Mr Joshua Graham
Managing Director
PF FORMATION PTY LIMITED
1 Patricia Fay Drive
MARTOOTA New South Wales 2756
28/10/2021

Hitchcock Road Quarry (MP06_0104-Mod-1)
Request for additional information

I refer to the assessment of the modification application for the Hitchcock Road Quarry (MP06_0104-Mod-1). Additional information is needed to progress the application, please refer to **Attachment 1**.

Figure 6. Location of PCT in proposed offset area

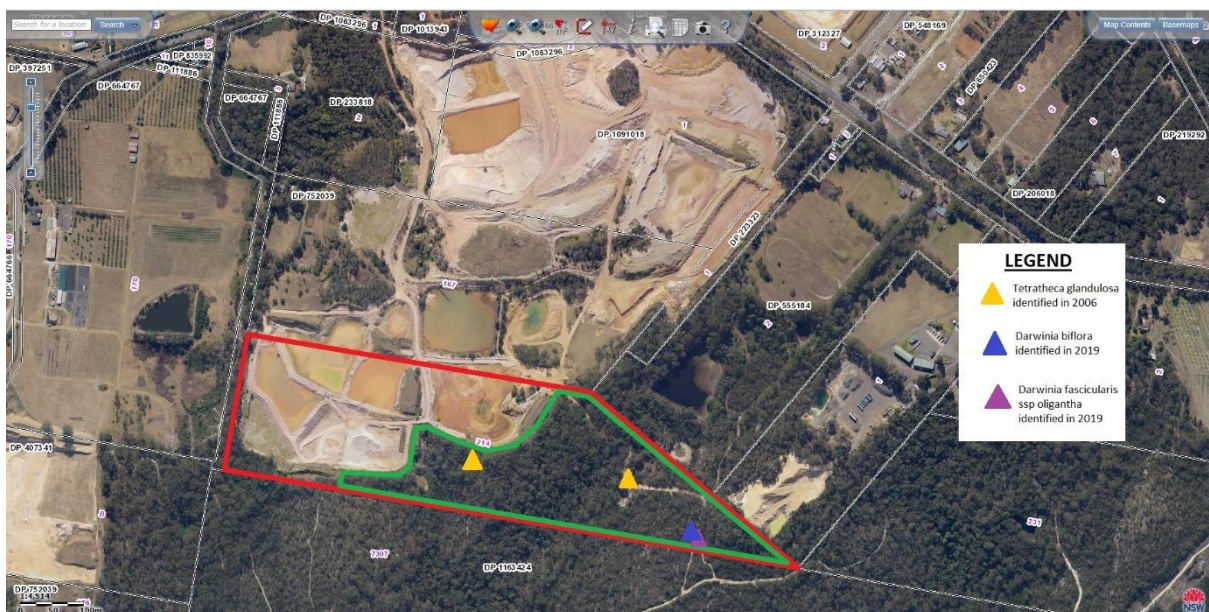
Regarding the proposed biodiversity offset on Lot 214, DP752039. Can you confirm whether this lot formed part of the original project application and was amended and removed as part of the Preferred Project Report to avoid the endangered ecological communities and threatened species on this land? What relevance does this have to the proposal to use this land as an offset for the modification application?

**APPENDIX 5
VEGETATION OFFSET PLAN**

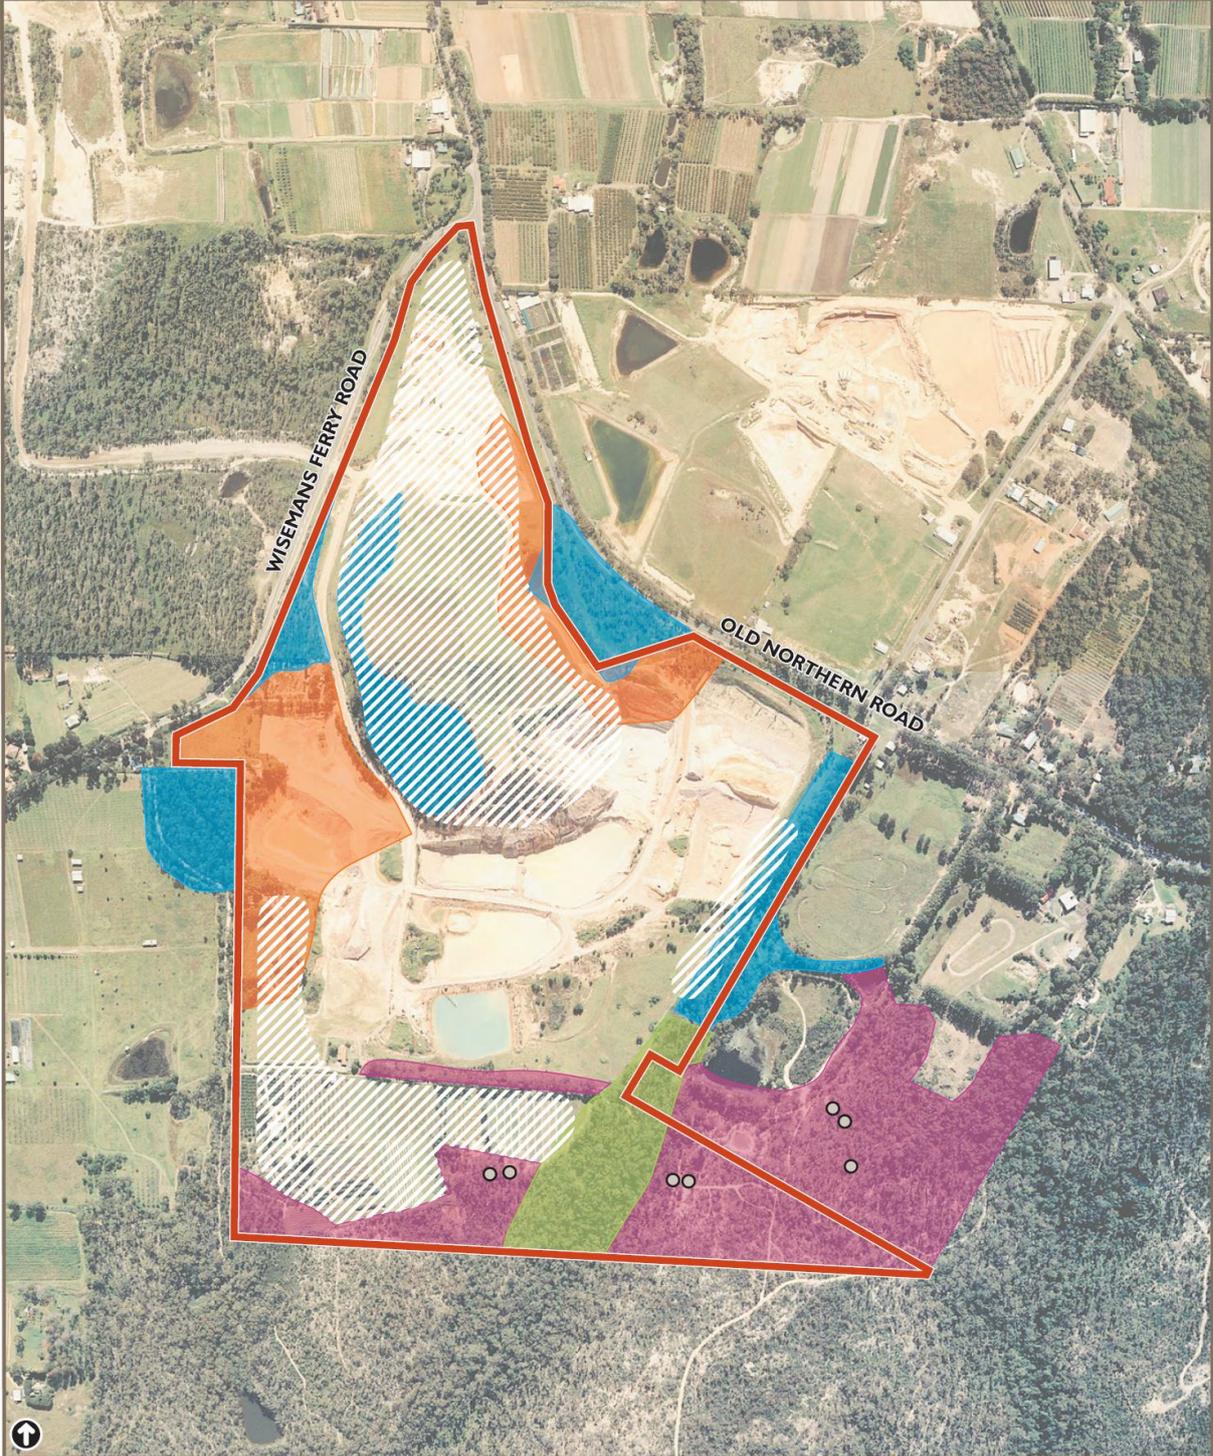
1. Regarding the implementation of the approved final landform described as Strategy A and Strategy B under condition 21 of Schedule 3 and shown in Appendix 7:
 - a. The modification application is unclear on which final landform you seek to implement and if there are any changes to either. Please provide information detailing which strategy is being implemented and any proposed changes to the final landform.
 - b. Please provide details on the reasons for implementing either Strategy A or B, or an amended version of either. You must also take into consideration the justification of the two strategies as detailed in the Preferred Project Report (refer to the definition in the existing development consent).

2. It is unclear if the modification application seeks approval to clear additional areas of vegetation compared to approved areas in the Preferred Project Report. You must review the approved areas of vegetation clearing in the Preferred Project Report against what has been cleared to date and what is being sought to clear. It is also unclear if the relevant conditions relating to these requirements need amendment.
